**KIRKLEES METROPOLITAN COUNCIL
INVESTMENT & REGENERATION SERVICE**

DELEGATED DECISION TO DETERMINE PLANNING APPLICATIONS

Reference No:	2025/62/92536/W
Site Address:	97, Blacker Road, Birkby, Huddersfield, HD1 5HQ
Description:	Alterations to convert basement to habitable space (within a Conservation Area)
Recommending Officer:	Molly Storer

DECISION – Full Conditional Permission

Drawing Title:  
Proposed Floor Plans & Elevations

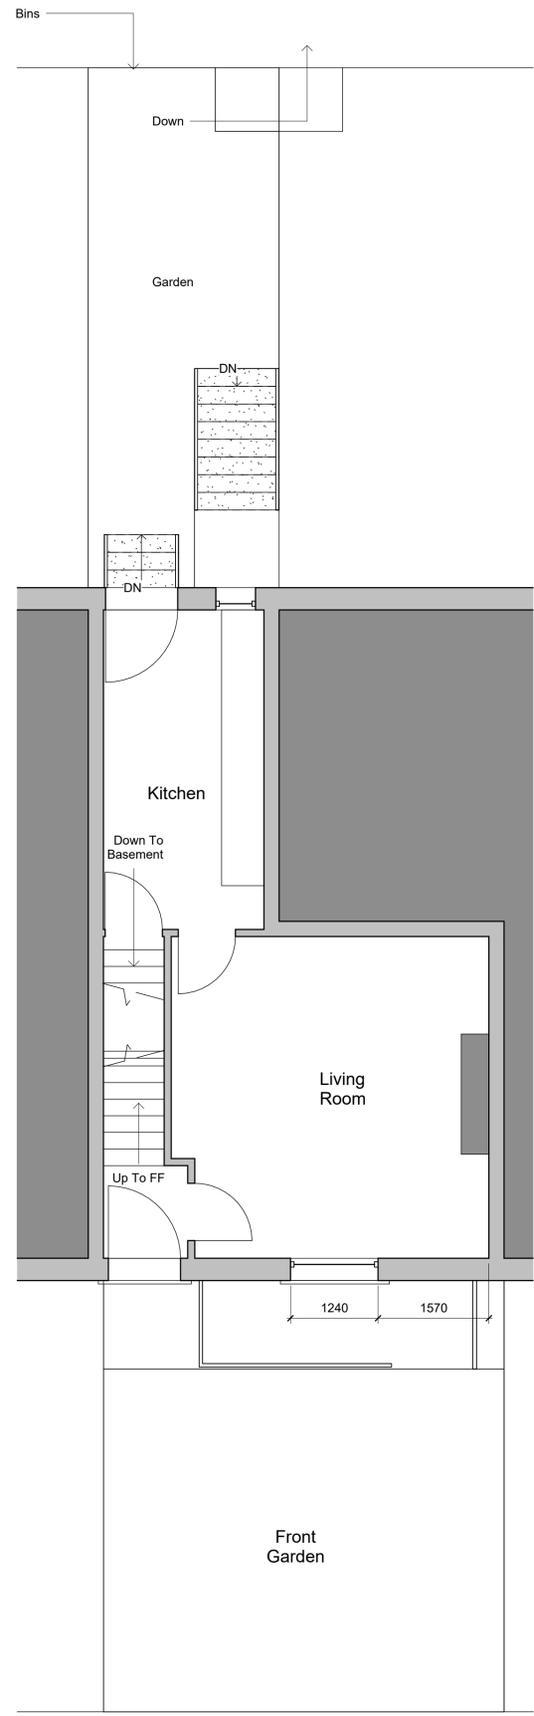
The existing basement is to be dug out to match the existing footprint at ground floor level of the dwellinghouse. This enlarged basement will provide a children's play room and WC. 2 new windows are to be installed within the front elevation and a glazed door within the rear elevation. A set of railings and escape ladder will be installed.

As the proposal relates to extending the existing basement out to be in line with the existing footprint of the ground floor of the house, the majority of alterations will be undertaken underground and would therefore not impact on the visual amenity or character and appearance of the Conservation Area. Whilst new windows and doors are to be installed within the property, they will be dropped down from ground level and are considered to be appropriate in this location. The railings and escape ladder will be of a limited height and it is not considered that this would be harmful to the appearance of the conservation area. To ensure that the railings have an appropriate colour for the conservation area they will be conditioned to be black.

This neighbouring property is located to the south east of the application site, and whilst it is noted that a new glazed door is to be installed within the south eastern elevation of the host dwelling, as this door is to be set down from the existing ground level and will be viewed amongst other existing doors and windows the rear elevation of no. 97 it is not considered that there are any concerns in respect to overlooking or loss of privacy.

4. The hereby approved railings and escape ladder shall be black in colour.
